5 May 2015

Our Ref: SE/CL/2015/39037/S

App Ref: 15/00153/REM
Site: Heyford Park, Camp Road, Upper Heyford, Bicester, OX25 5HD
Proposal: "Reserved Matters to Outline application 10/01642/OUT - Village green including sports provision."

Village Green Landscape Proposals
Scale 1:200

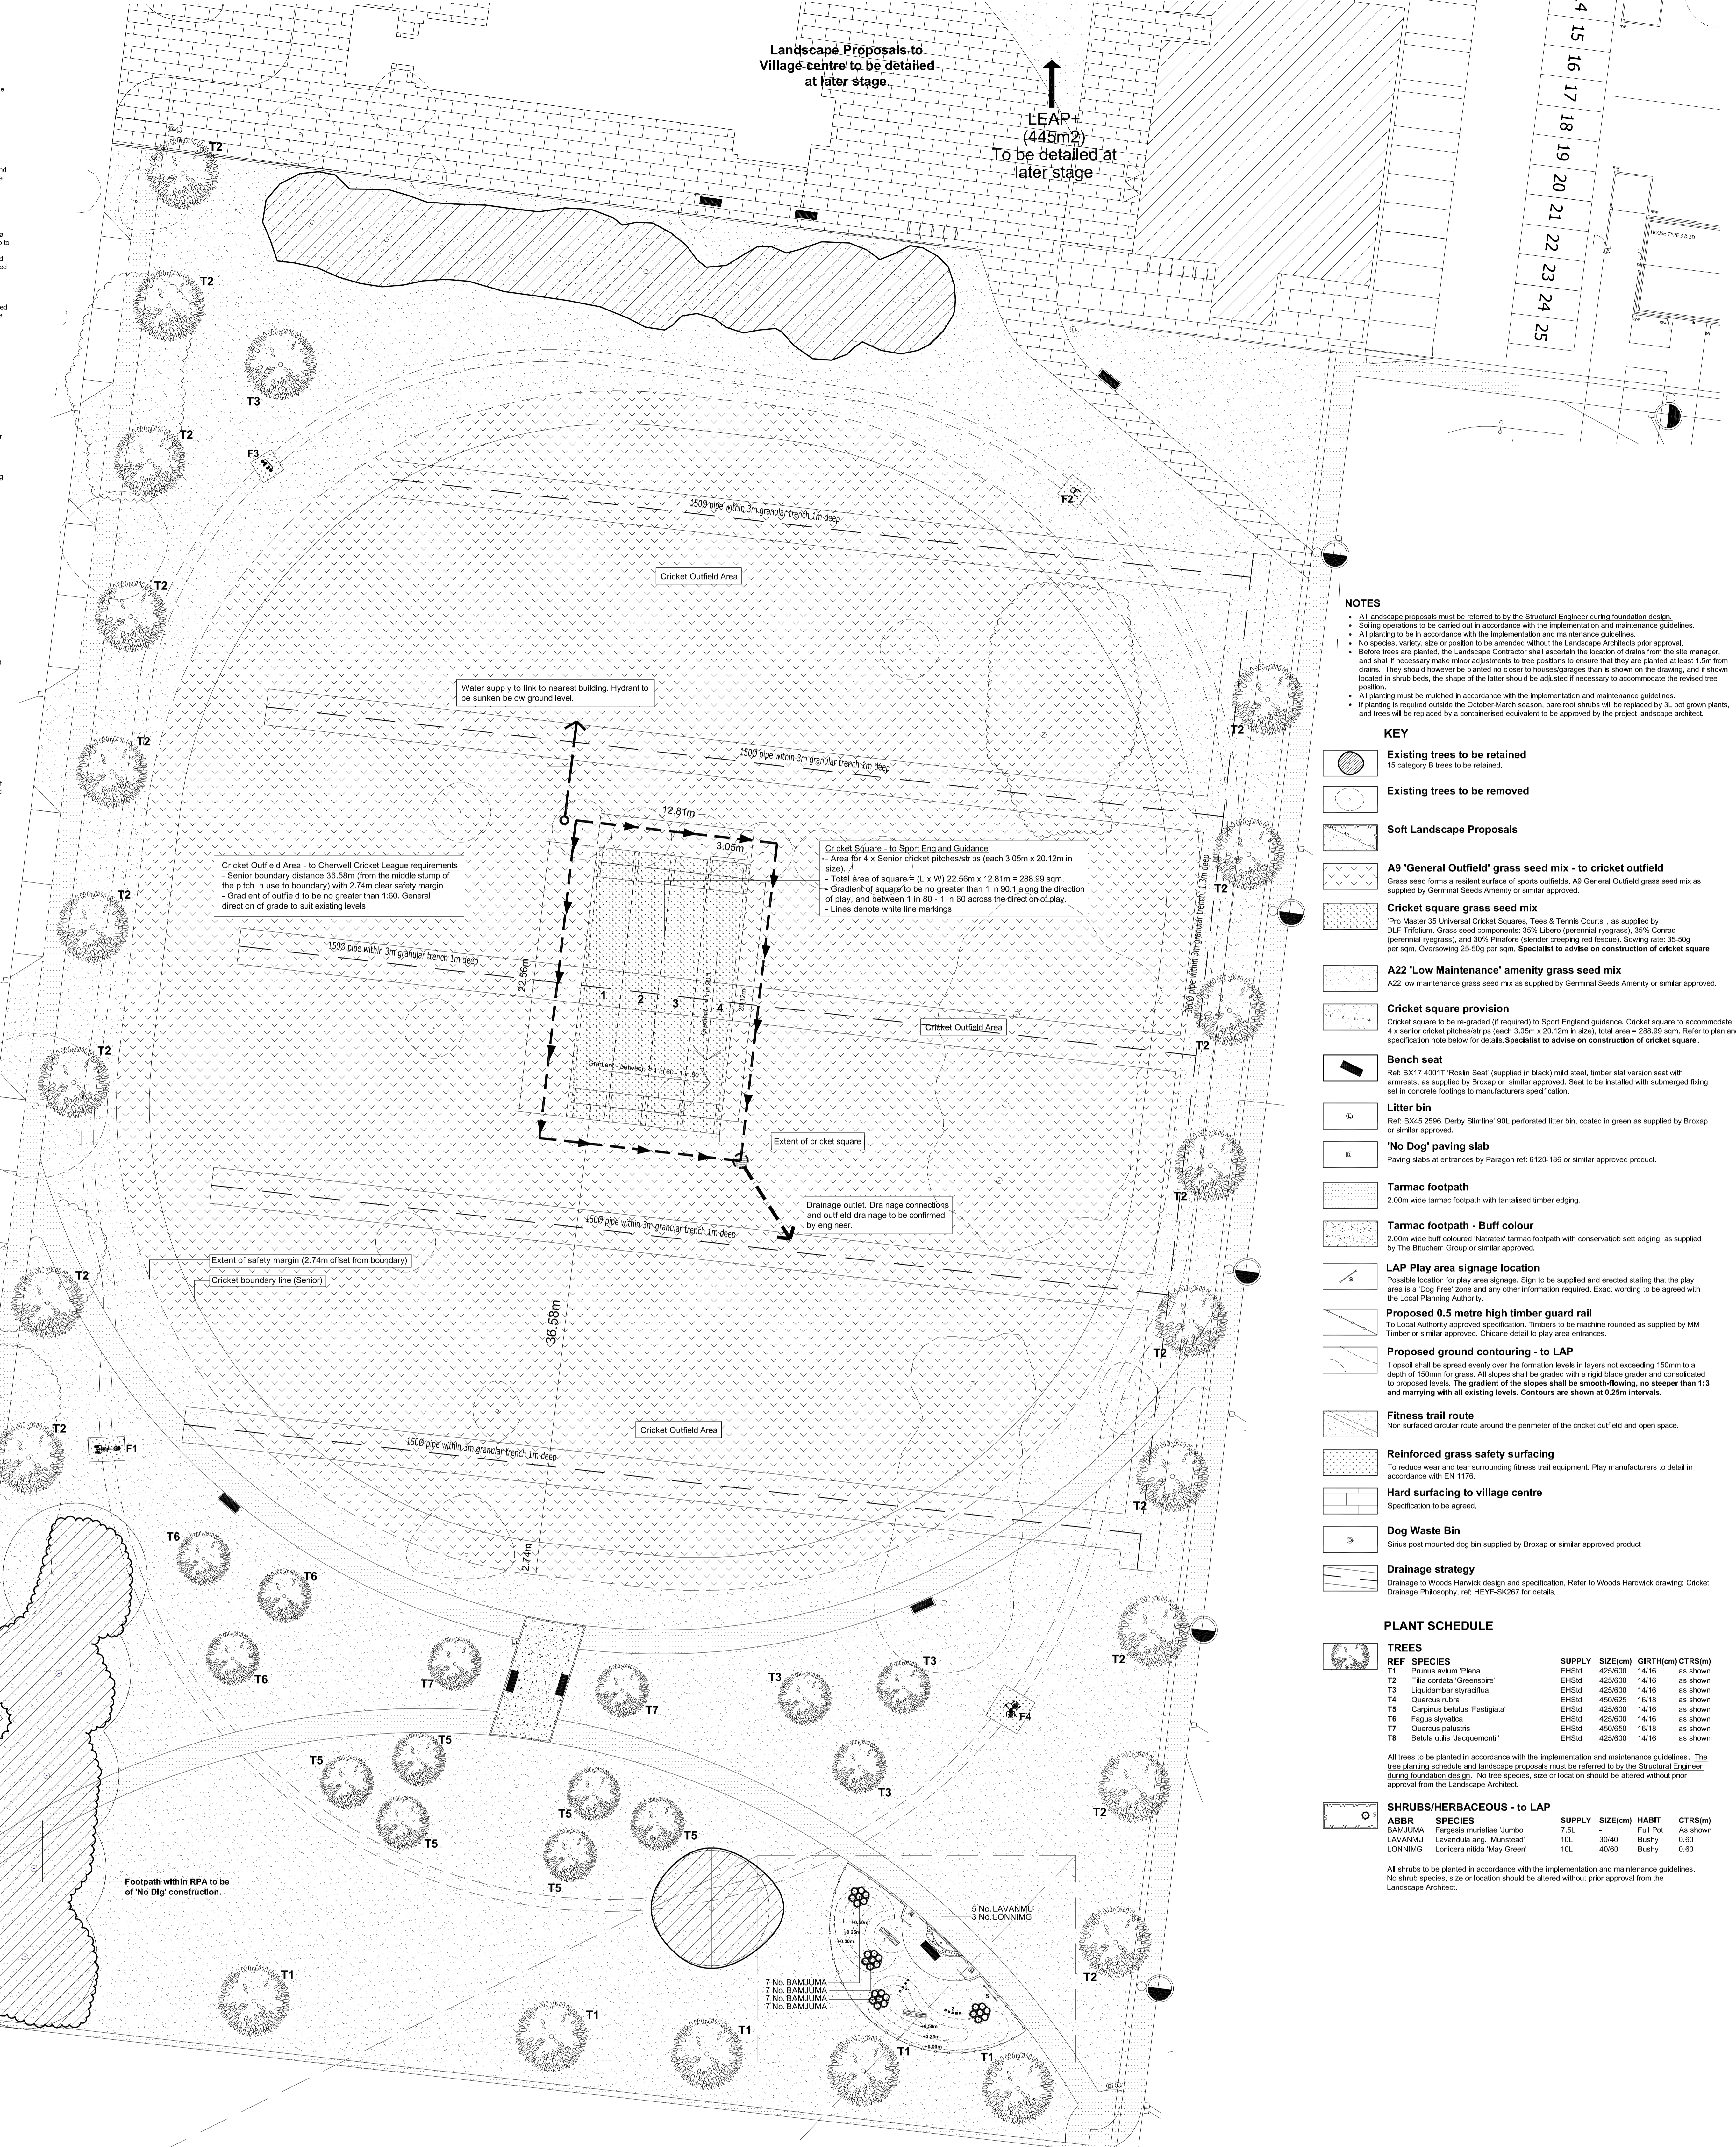
The revised drawing shows replacement of the four grass wickets with one artificial wicket, an increase in the distance to the boundary of the outfield and the provision of ball stop nets adjacent to the footpaths on the east and west sides of the proposed village green. The drawing is annotated with a note that reads:

"Location of ball defensive barrier. Fixed posts with netting hoisted into position during cricket match situations. 5 to 6 metres in height, netting colour – green, posts positioned at 10m intervals. Cricket/Football ground perimeter protection net system, as supplied by Stadia-sports.co.uk or similar approved."

The ECB also recommends that provision be made for ball stop netting, when required, and that a company such as Labosport Ltd be consulted to provide a technical assessment of the detailed requirements.

From the additional information provided and the views of the ECB, it is considered that the site would be capable of satisfactorily accommodating a single artificial wicket and an outfield of a size that accords with published guidance. However, it is still likely that the proposed development would give rise to a conflict between the use of the village green for cricket and the neighbouring uses, particularly housing. Ball stop netting on posts has been proposed to mitigate the risk of cricket balls leaving the site, but the height of the netting needs to be determined by an independent risk assessment. It also needs to be clearly understood who will have control over it and who will be responsible for its maintenance.

A risk assessment, by a company such as Labosport Ltd, could be undertaken prior to a decision being taken or, if the Council is minded to approve the application, in accordance with a suitably worded planning condition. In the case of the latter, the Council will first need to be satisfied that there will be no harm to the amenities of the locality in terms of the appearance of the posts and the netting irrespective of their potential height.

The cricket pitch hereby permitted shall not be constructed other than substantially in accordance with the ECB's Performance Standards for Non-Turf Cricket Pitches Intended for Outdoor Use [TS6] Revised November 2007.

- (i) A detailed assessment of the risk of cricket balls leaving the ground and potential solutions to reduce the risk to an acceptable level.
 - (ii) Based upon the results of the assessment to be carried out pursuant to (i) above, a scheme that is designed to prevent balls from leaving the playing field area. The scheme shall include full details of all structures to be erected, who will have control over them and who will be responsible for their maintenance.
- b) The approved scheme shall be carried out in full before first use of the cricket pitch. The land shall thereafter be maintained and made available for playing field use in accordance with the scheme.
